Ribble Valley Borough Council
Housing & Development Control

Application no: **3/2020/0830**

Address: **7 Manor Avenue Ribchester Lancashire PR3 3XN**

Proposal: **Demolition of single storey side and rear extension with replacement two storey side extensions, detached garage and single storey rear extension**

PROPOSED SITE PLAN SCALE 1:200

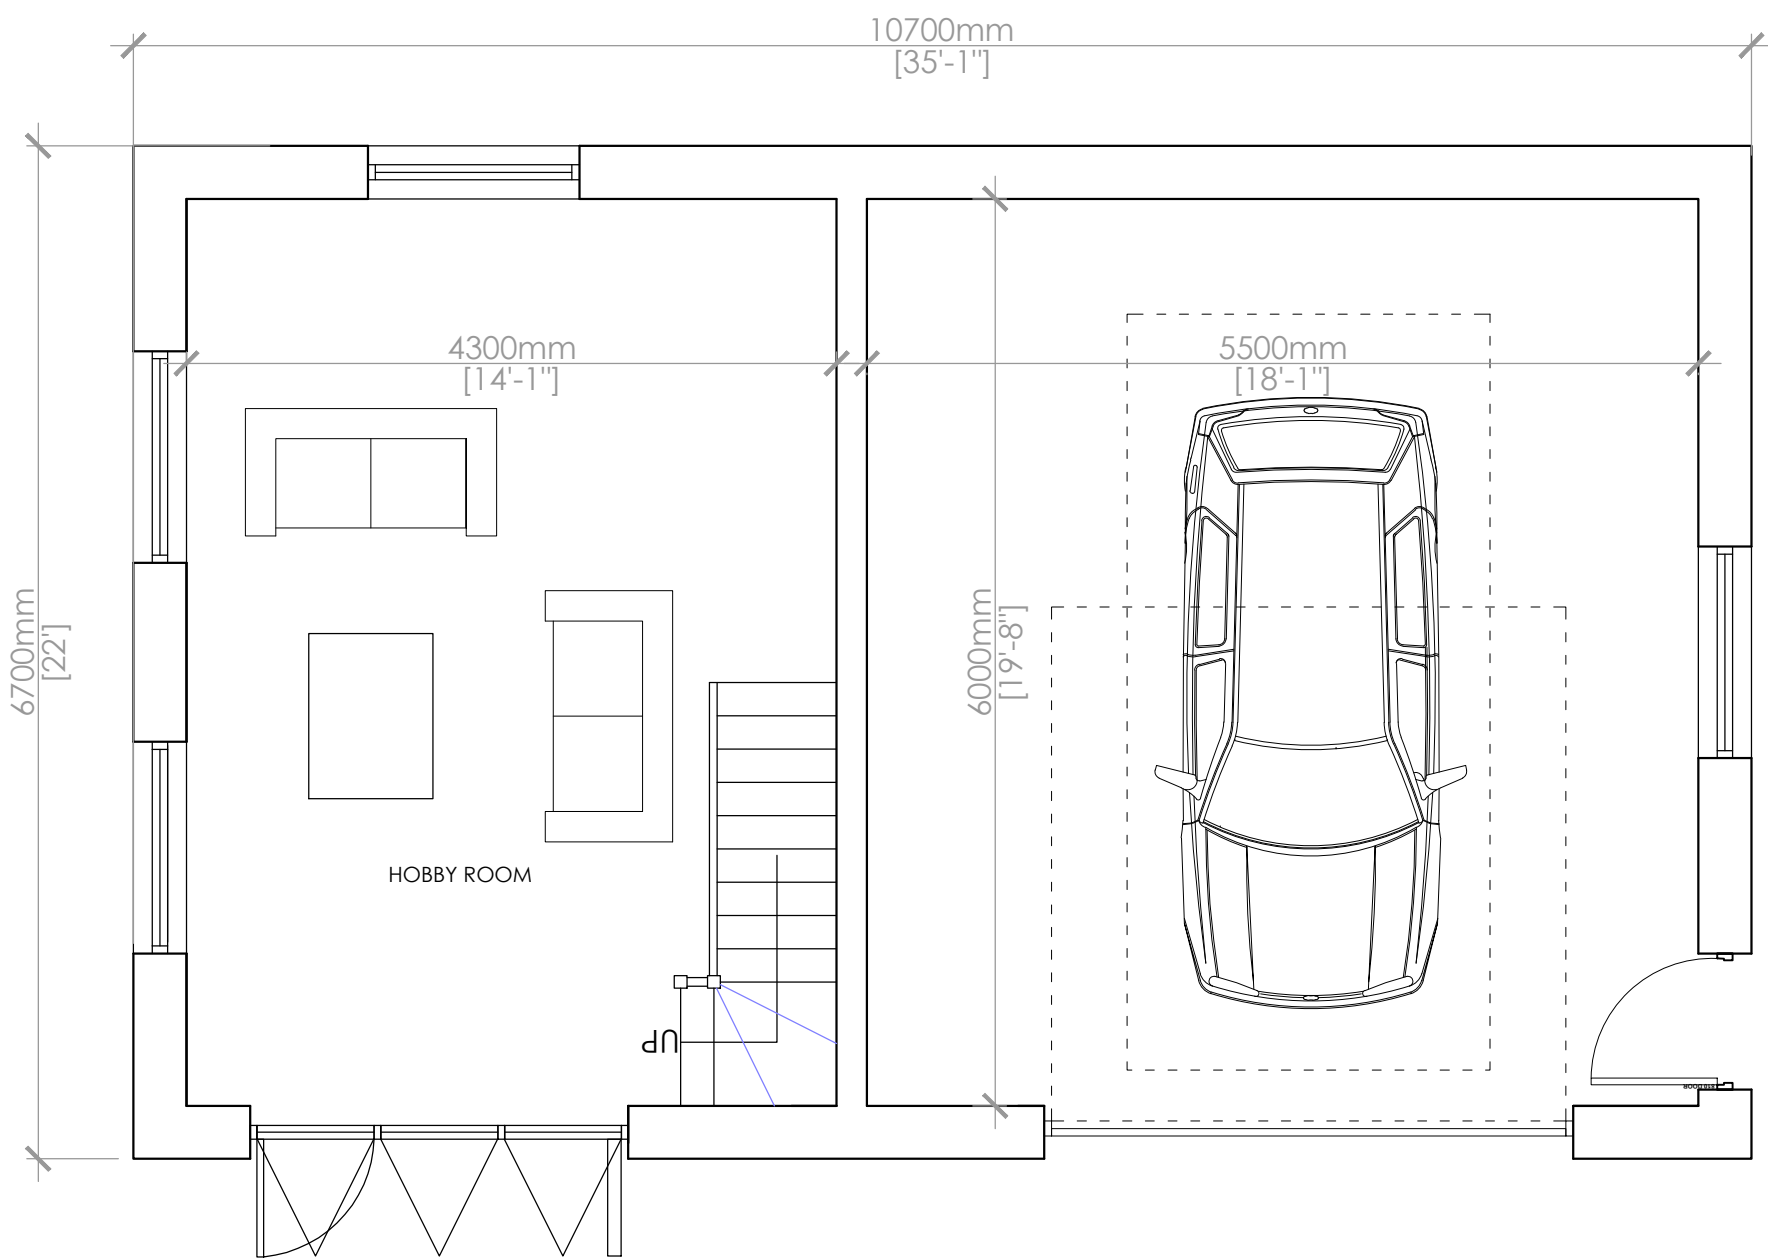
Whilst I would raise no objection to the principle of the proposed development, I would need to be satisfied that the access arrangements are suitable for the proposal, I therefore ask that an access arrangement plan is submitted, detailing the proposed access arrangements including dimensions.

The plans show a gravel driveway is proposed, the first 5m into the driveway will need to be bound with an approved surface material to prevent loose stones from being brought into the public highway, a vehicular dropped crossing will also need to be installed under section 184 of the Highways Act 1980.

I request that an access arrangement plan is submitted, as mentioned above.
